Arun District Council  
Arun Civic Centre  
Maltravers Road  
Littlehampton  
West Sussex BN17 5LF  
Planning & Building Control General  
Enquiries  
Tel: (01903) 737756 Fax: (01903) 716019  
Dx: 57406 Littlehampton  
Minicom: 01903 732765  
e-mail: [planning@arun.gov.uk](mailto:planning@arun.gov.uk)  
website: [www.arun.gov.uk/planning](http://www.arun.gov.uk/planning)  
**Our Ref: A/43/11/**  
**Your Ref:**

**Demolition of existing bungalow and store & provision of new 2 storey dwelling & new storage unit**  
**Herons Farm Dappers Lane Angmering**

I regret that I am unable to accept your documents as a formal application until the following matters have been resolved :-

CLIENT Mr & Mrs Ayling			
Issue Details		By Date	
SCALE		AS SHOWN	
DATE		2/8/10	
DRAWING NUMBER		9107/01

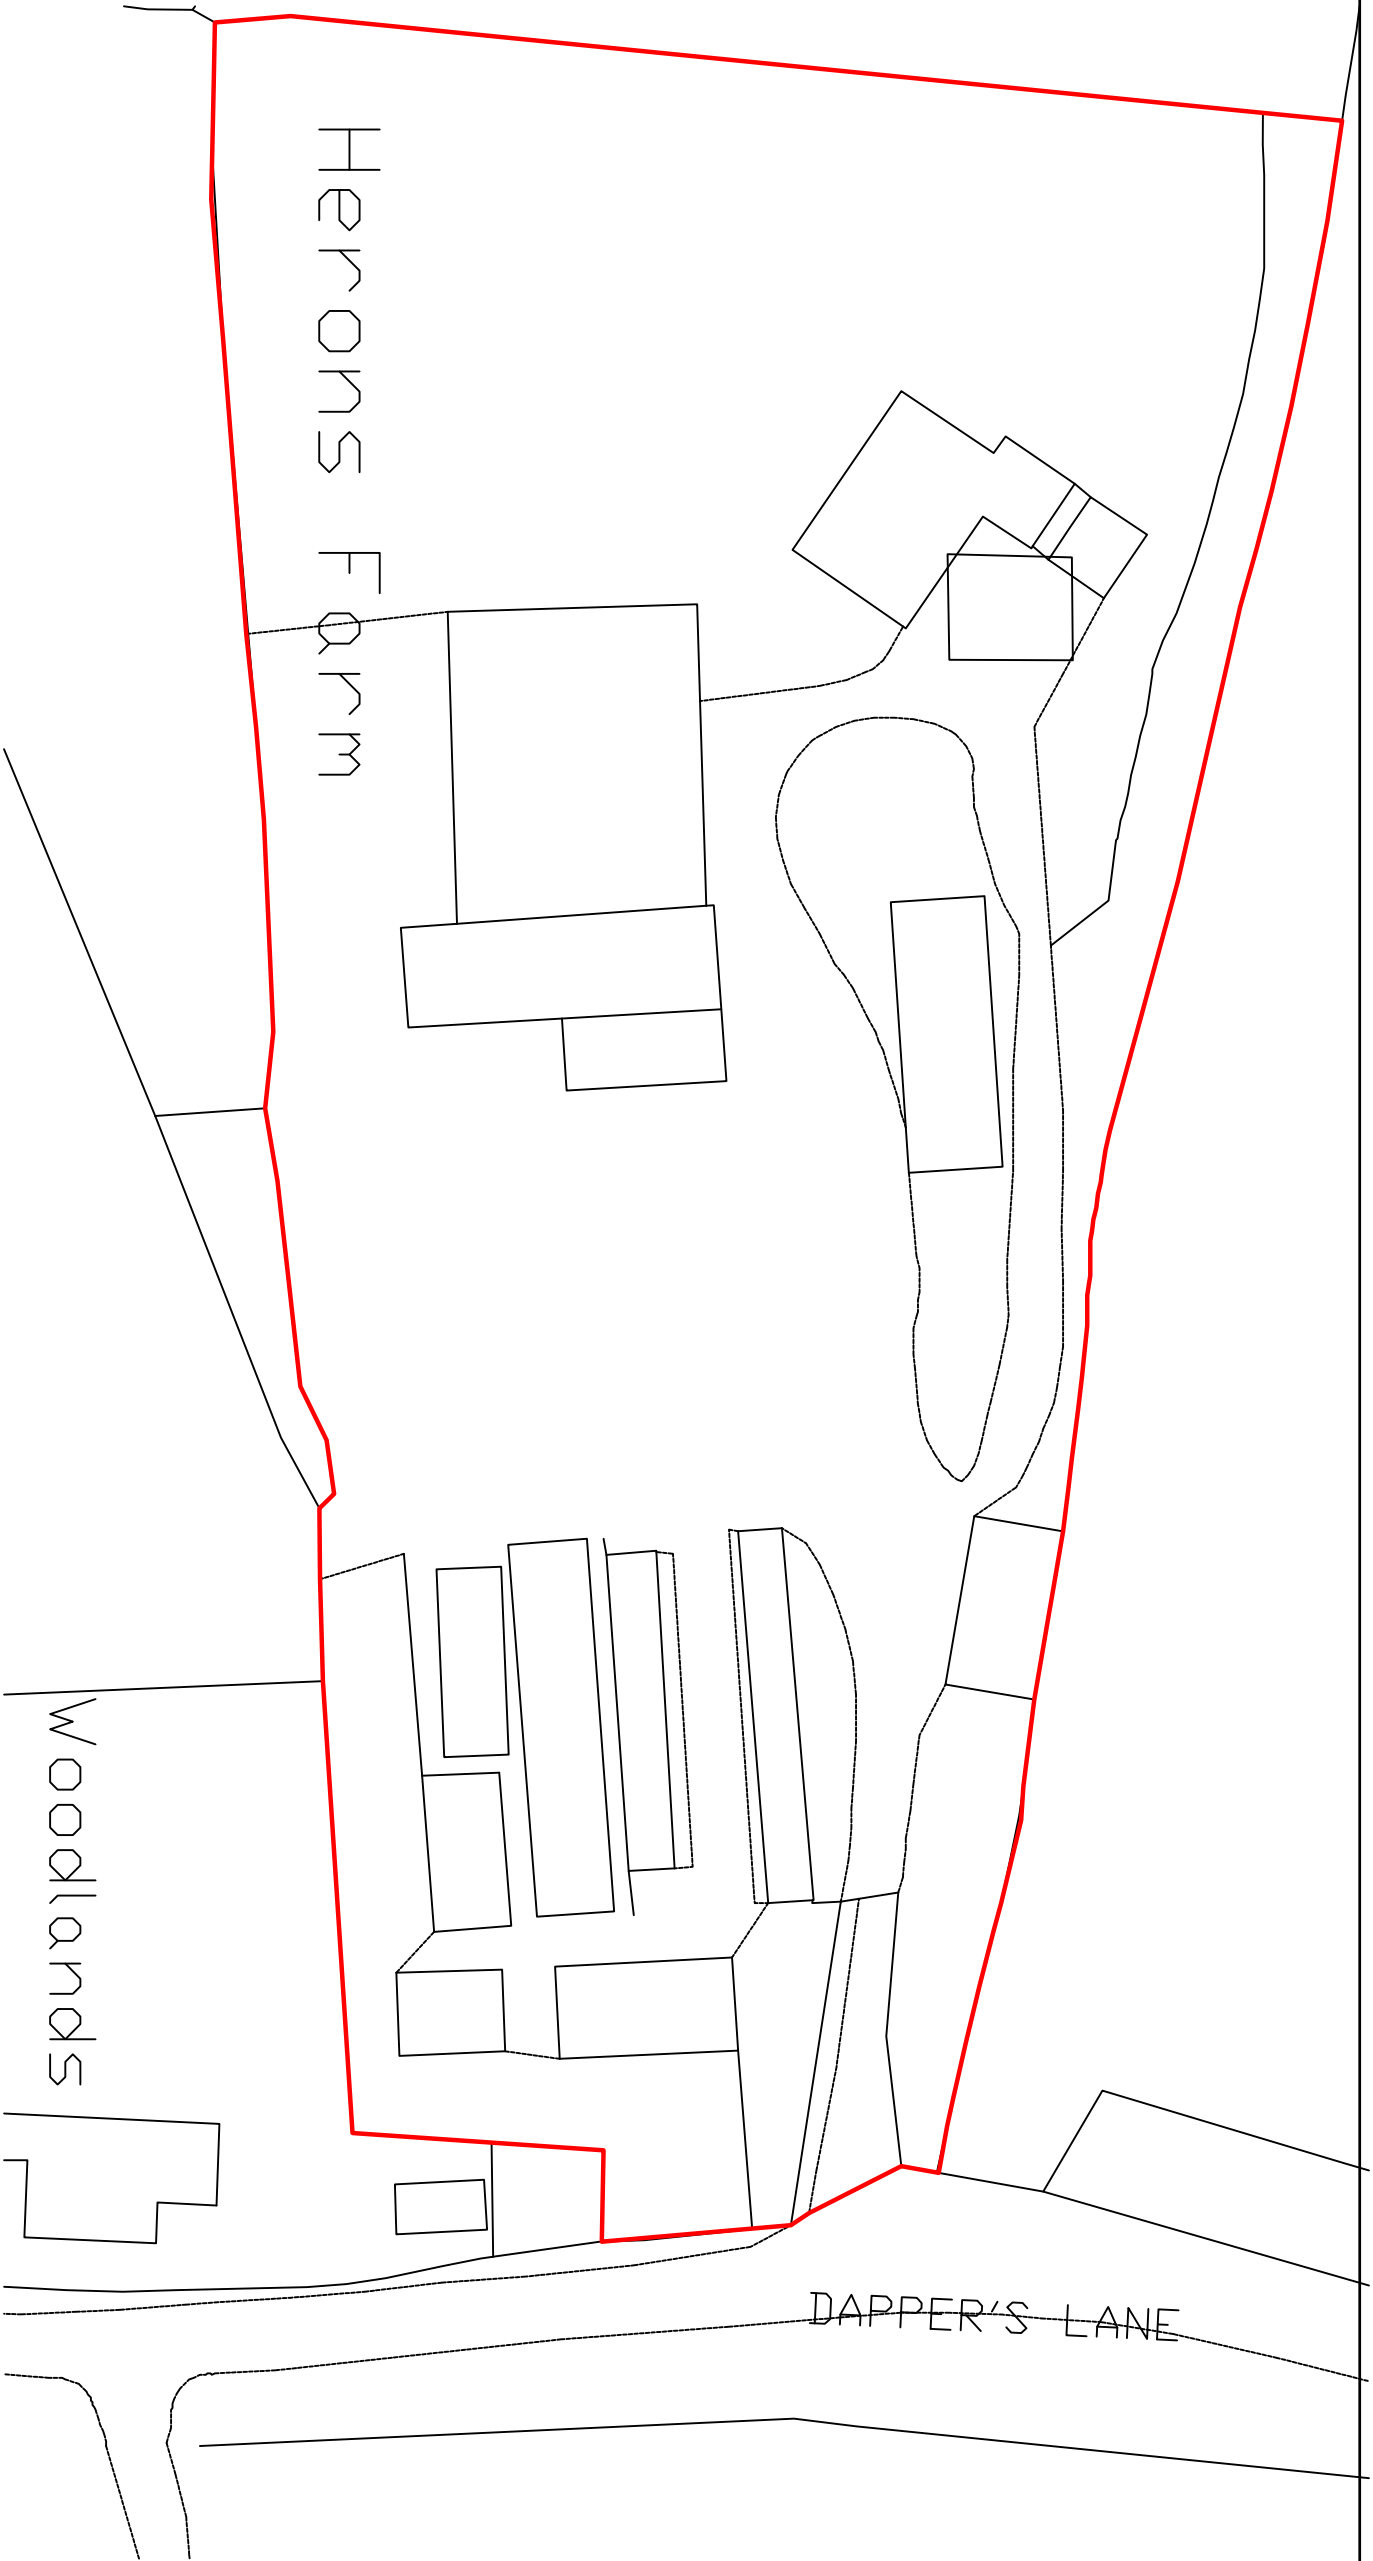
I require 1 electronic or 3 paper copies of a revised site plan to show the bin storage arrangements. Please also clarify the parking spaces as the plan shows 8 spaces and the application states there are 4 spaces.

EXISTING REAR - NORTH

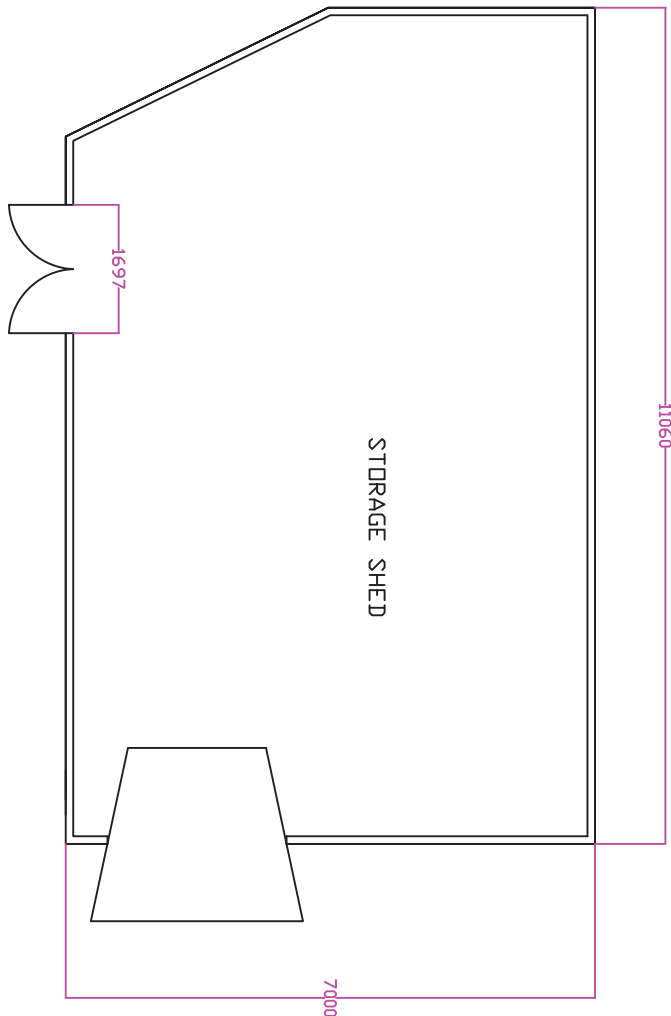
Please provide 1 electronic or 3 paper copies of an existing north elevation for the storage shed and elevations of the existing dwelling, in accordance with the guidance notes available on our website detailed below (click on National List).
